Appeal Decision

Appeal Ref: APP/R5510/W/19/3236950

Land at 30 - 32 Chester Road, Northwood, Middlesex HA6 1BQ

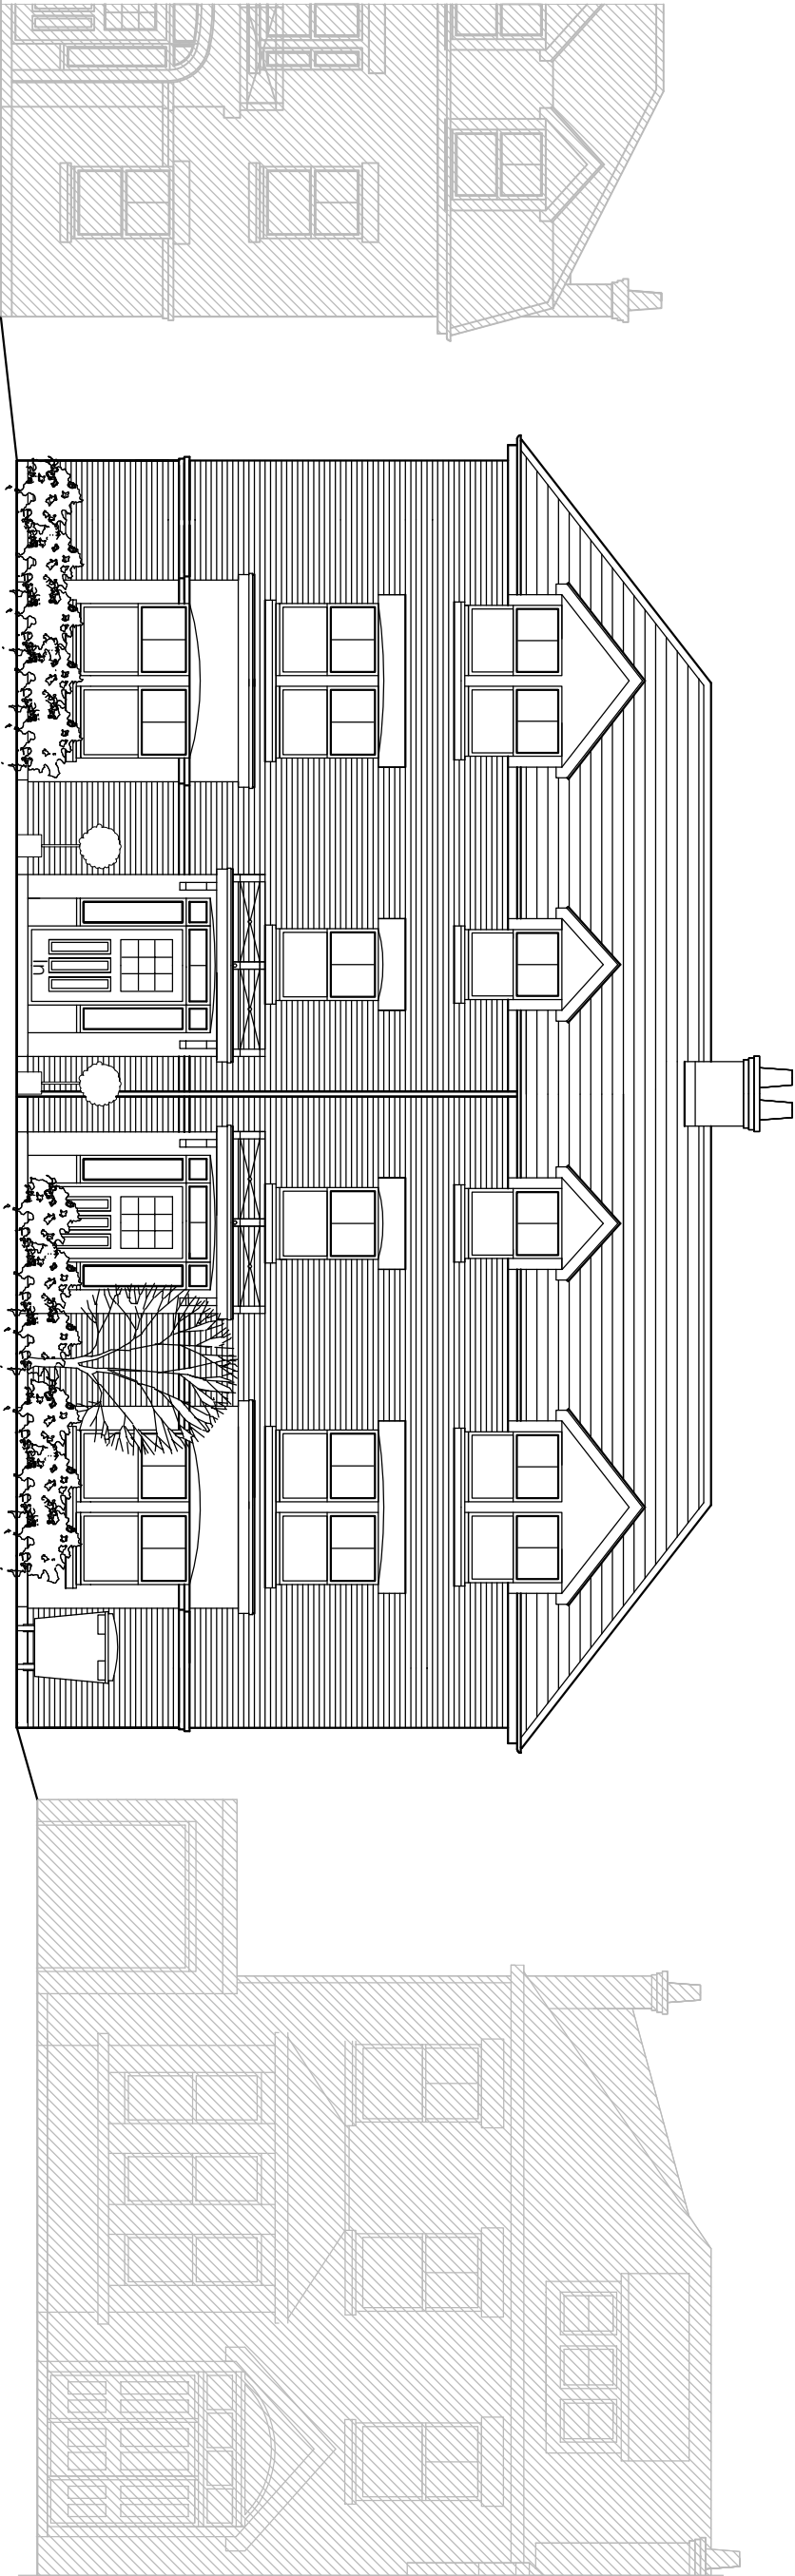
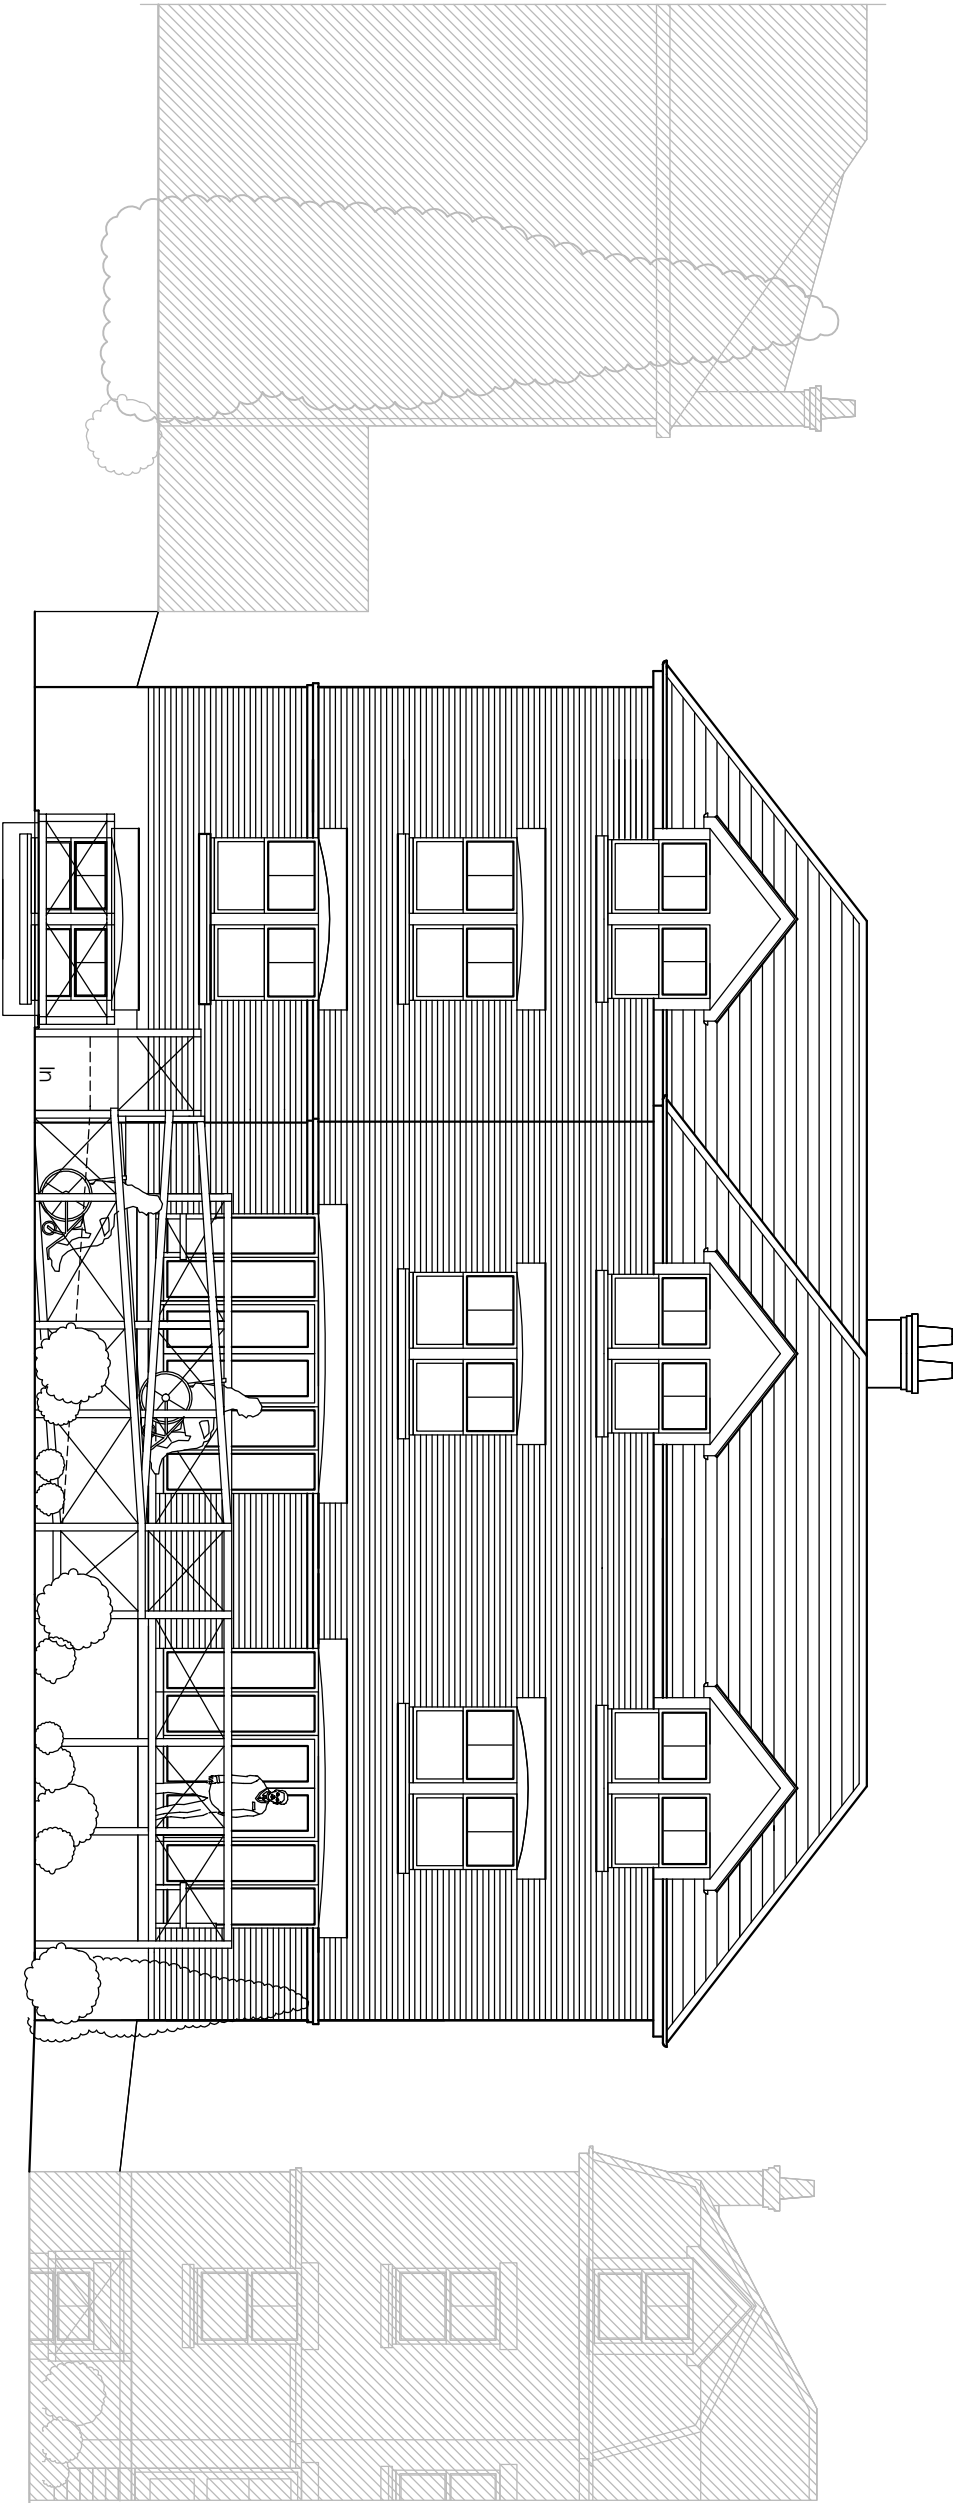
6. The raised eaves on the appeal proposal would intersect mid-way through the second-floor windows on the front and rear elevations of the building. The windows to either end of the second floor level would also be double width. The combination of these factors would give the impression of increased height, bulk and scale, particularly when compared with the neighbouring care home at No 34. Even accounting for the position of the eaves and ridge at similar level to the respective roof levels on the neighbouring dwellings at Nos 28 – 26, the additional brickwork above the first floor and the incursion of the second-floor windows within this area would give the building more of a three-storey presence. Consequently, the design is at odds with the building heights predominant in the area and the generally more subservient approach to providing second floor accommodation seen on neighbouring buildings and elsewhere on Chester Road.
